Development Review Board 10/3/07 Agenda Item #16 Sketch Plat: Lots 33, 34, & 35, Block D, Kimo Addition

RE: Lots 33, 34 & 35, Block D KIMO ADDITION/sketch

DRB CASE NO/PROJECT NO: 1006840	AGENDA ITEM NO: 14
	SUBJECT:	
	Final Plat Preliminary Plat	
	ACTION REQUESTED:	
P.O. Box 1293	REV/CMT:() APP:(x) SIGN-OFF:() EXTN:() AM	END:0
	ENGINEERING COMMENTS:	
Albuquerque	No adverse comments.	
Jew Mexico 87103		
	RESOLUTION:	
ww.cabq.gov	APPROVED; DENIED; DEFERRED; CO	MMENTS PROVIDED; WITHDRAWN
	SIGNED-OFF: (SEC-PLN) (SP-SUB) (SP-BP) (FP)	BY: (UD) (CE) (TRANS) (PKS) (PLNG)
	DELEGATED: (SEC-PLN) (SP-SUB) (SP-BP) (FP)	TO: (UD) (CE) (TRANS) (PKS) (PLNG)
	FOR:	
	SIGNED: Bradley L. Bingham City Engineer/AMAFCA Designee 924-3986	DATE : January 2, 2008

PLAT OF
 LOT 35-A, BLOCK D
 KIMO ADDITION
 SECTION 12, T. 10 N., R. 3 E., N.M.P.M.
 CITY OF ALBUQUERQUE
 BERNALILLO COUNTY, NEW MEXICO
 DECEMBER 2007
 SHEET 2 OF 2

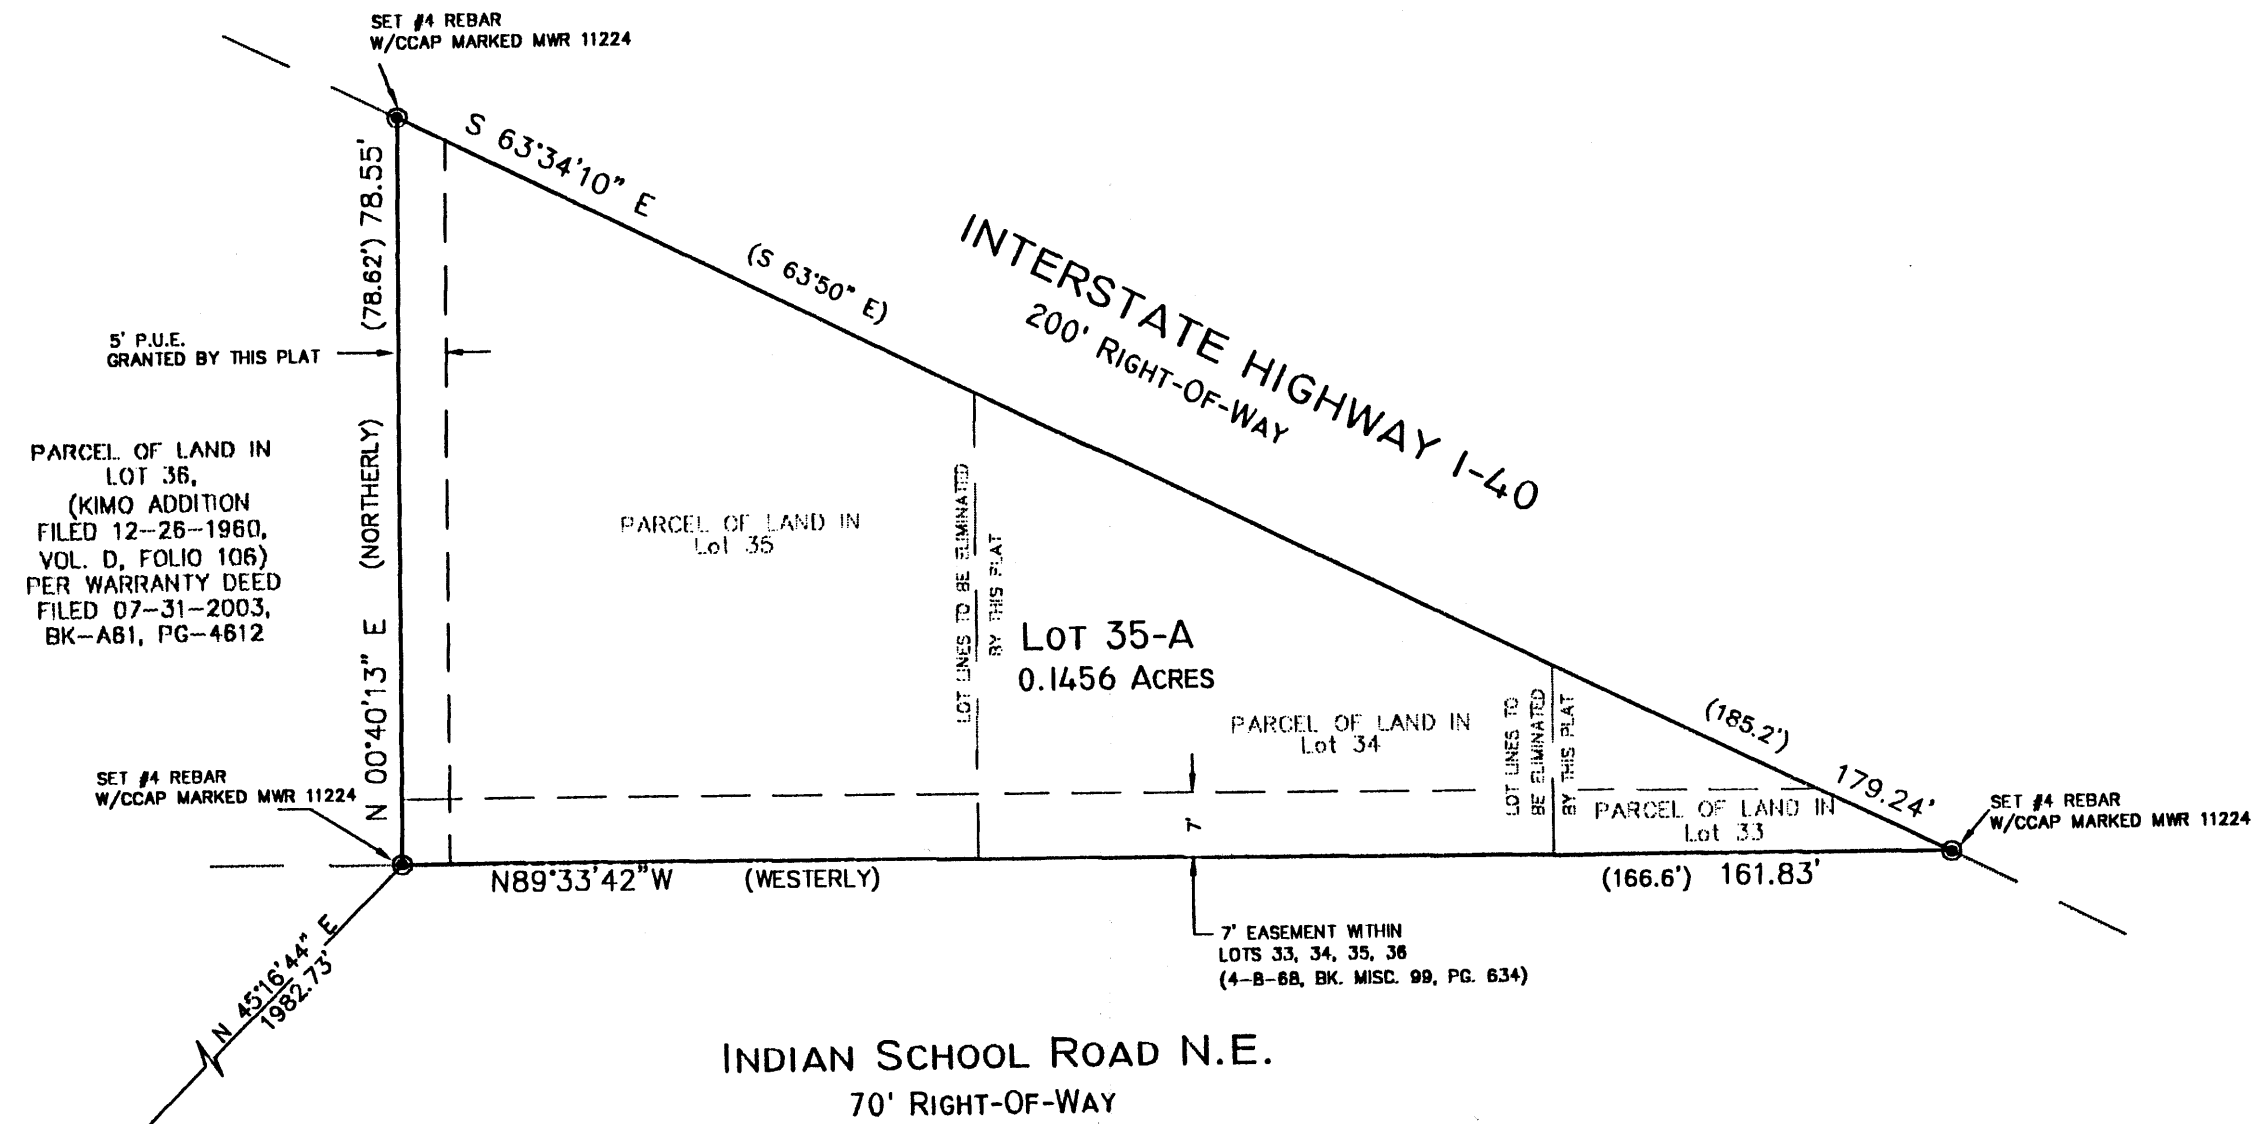
1) No objection to combining lots 33, 34 and 35. A 4' sidewalk will need to be extended along the frontage.
